Charlotte-Mecklenburg Planning Department

SUBJECT: Administrative Approval for Petition No. 1999-029C H.C. Grimmer Development CO., LLC

TECHNICAL DATA SHEET
 for
REZONING PETITION # 1999-029C

TECHNICAL DATA SHEET

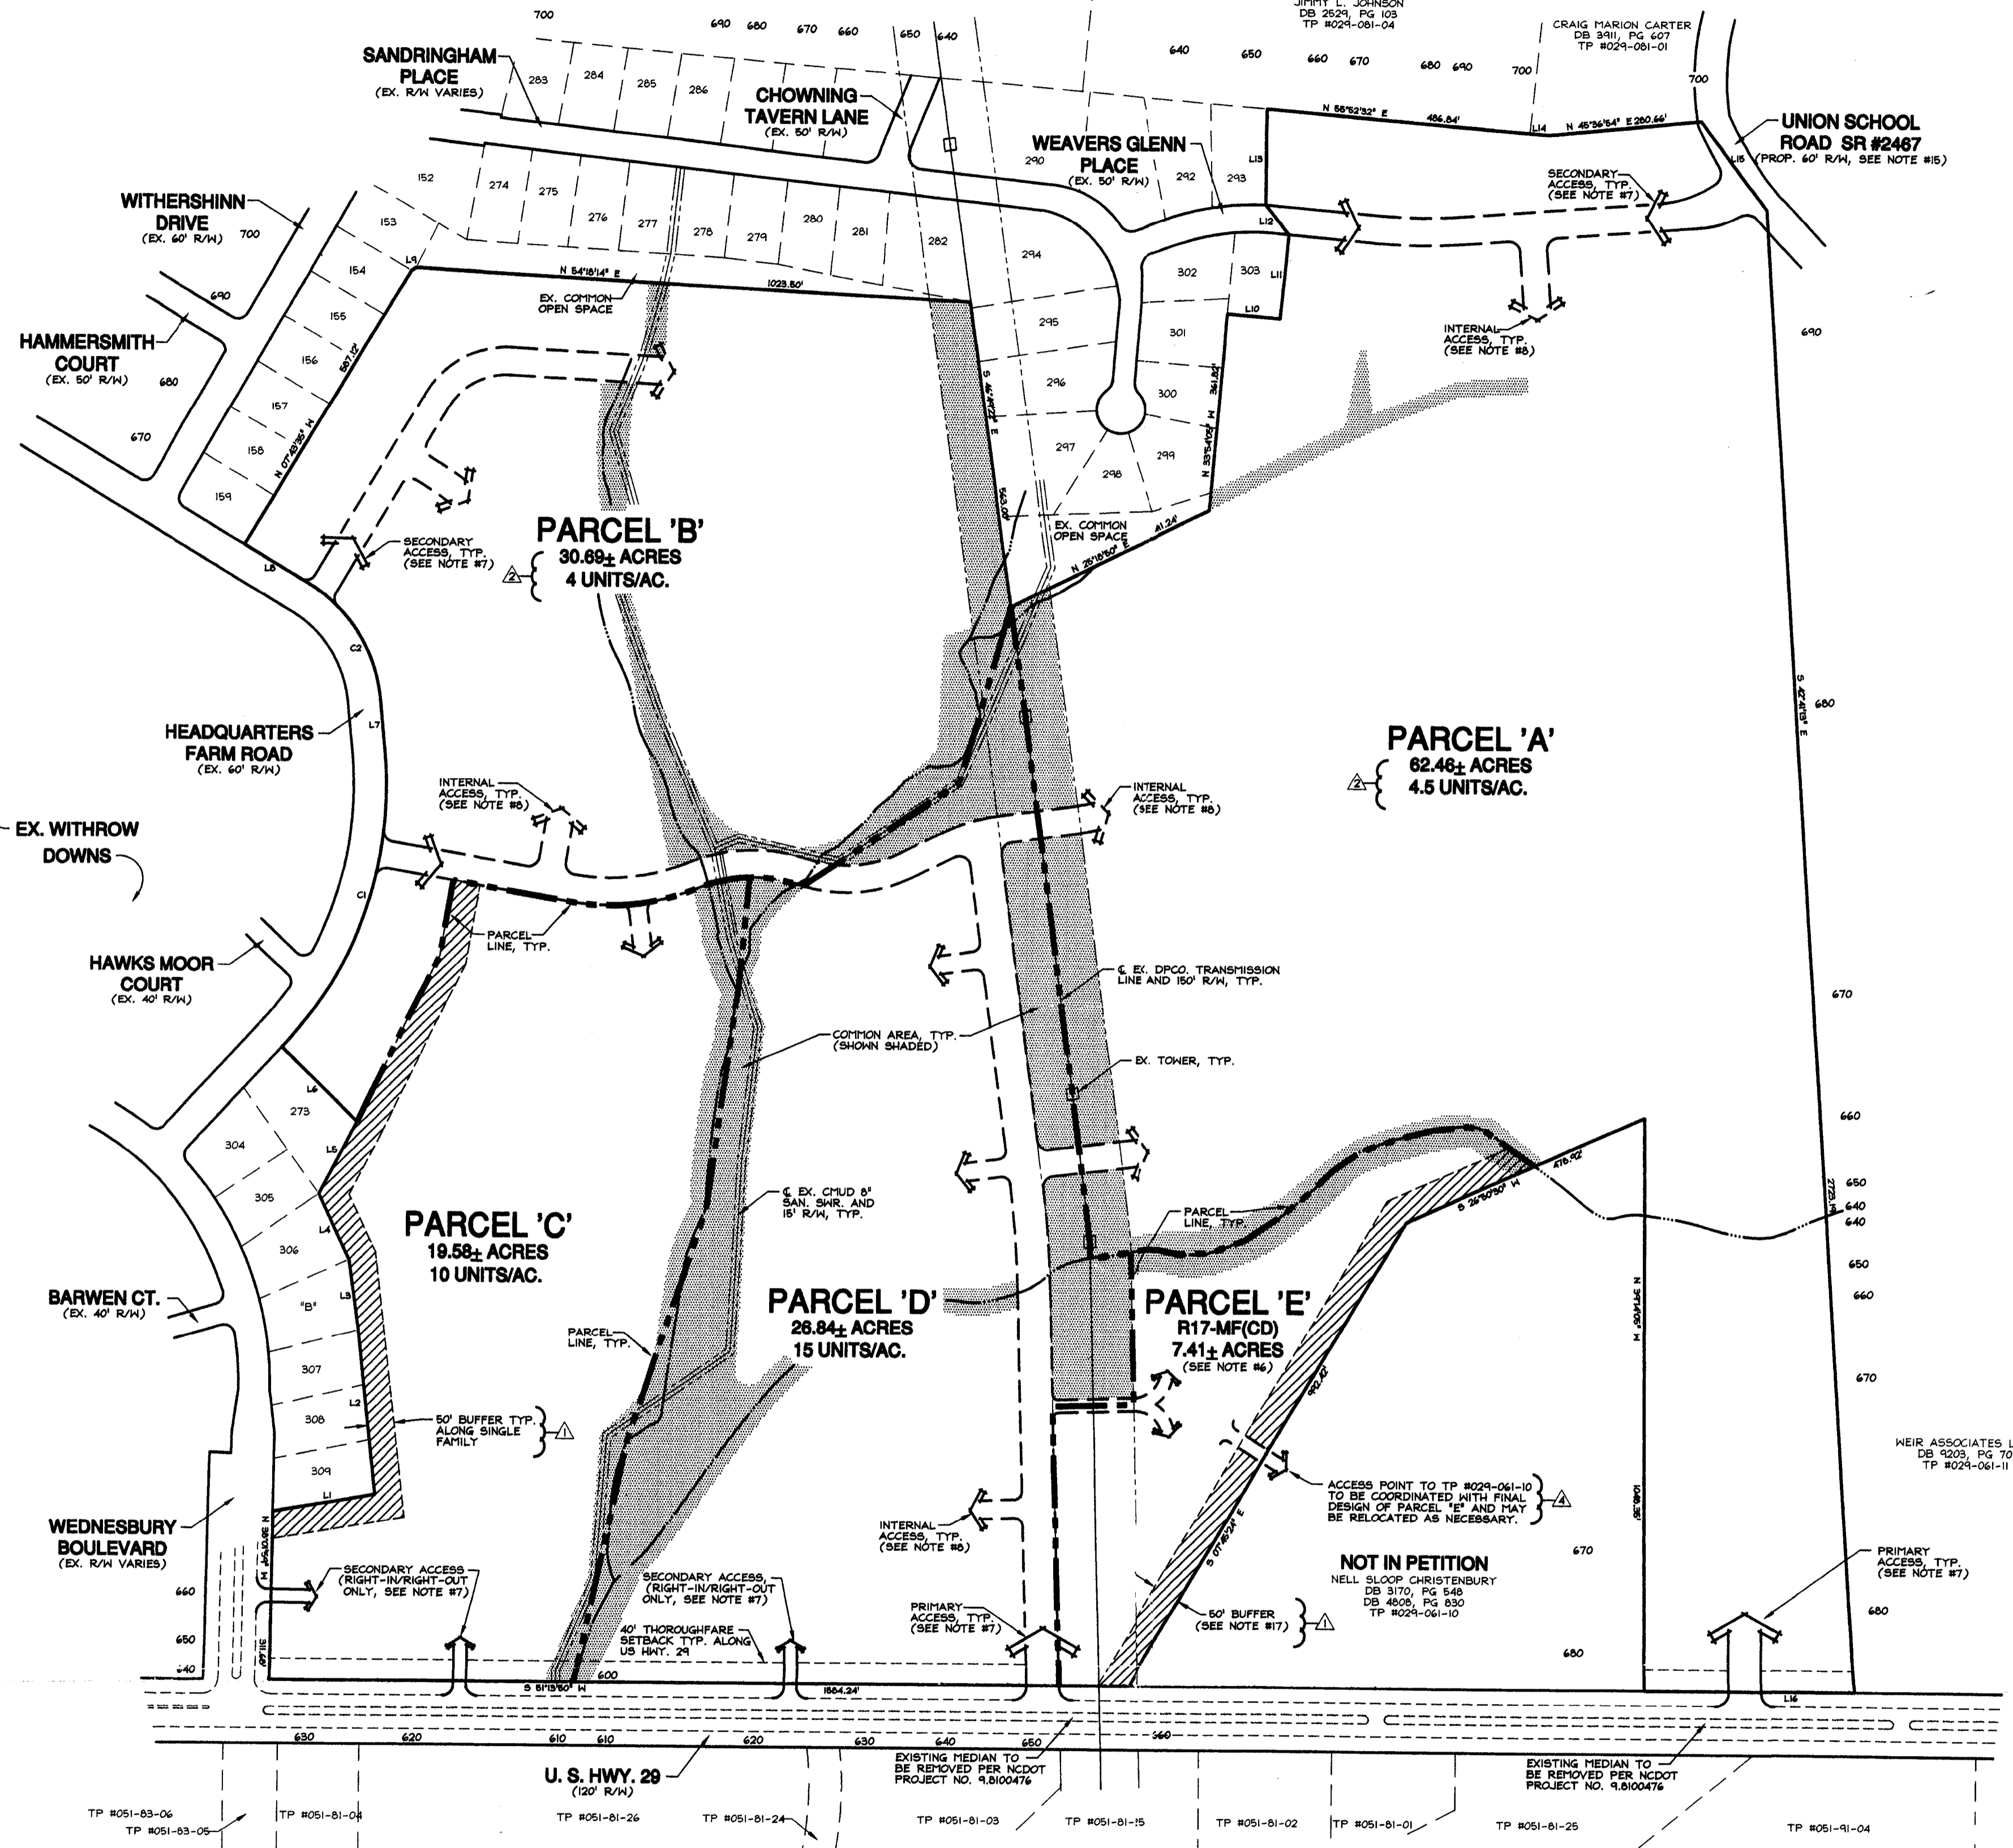
- To allow single-family attached and detached on parcel "C".

24. THE DEVELOPMENT OF PARCEL 'C' WILL CONSIST OF SINGLE FAMILY ATTACHED OR DETACHED HOUSING AS SPECIFICALLY DEFINED IN THE ZONING ORDINANCE, WHICH WILL BE OFFERED FOR SALE.
